11 April 2025  
Our ref: SSD-2/2025

**Uniting War Memorial Hospital Site - SSD-61389706**

Thank you for the opportunity to make a submission following the closing date of the exhibition period of the State Significant Application (the application) known as SSD-61389706 at the Uniting War Memorial Hospital Site.

Figure 13: Bronte Road Vehicular Access

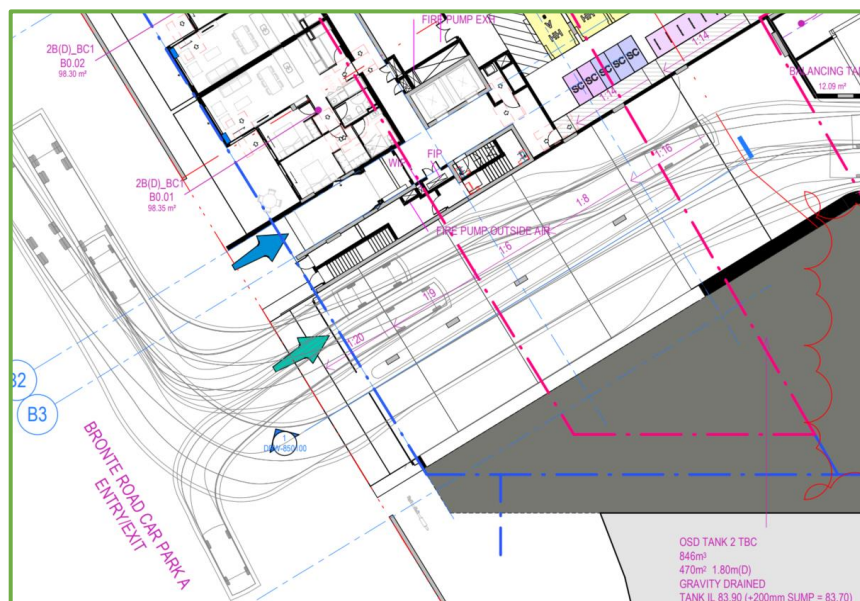
The proposed driveway widths to Bronte Road, Birrell Street and the north/south link result in an unnecessary loss of on street parking. Both Bronte Road and Birrell Street have a very high parking demand utilised by residents in the area. Furthermore, the unnecessary loss of parking to facilitate a private development (with multiple entrances) goes against multiple current Waverley Council values, objectives and controls.

The following adjustments to the driveway widths are recommended:

- Bronte Road – 3m entry, 3m exit, 1m separation.
- Birrell Street – 3.9m metre driveway inclusive of splays with a waiting bay required within the property boundary if the queueing demand requires per the relevant Australian Standards.
- North/south link – justification required for the proposed 6m entry/exit, otherwise, 3.9m inclusive of splays shall be required.
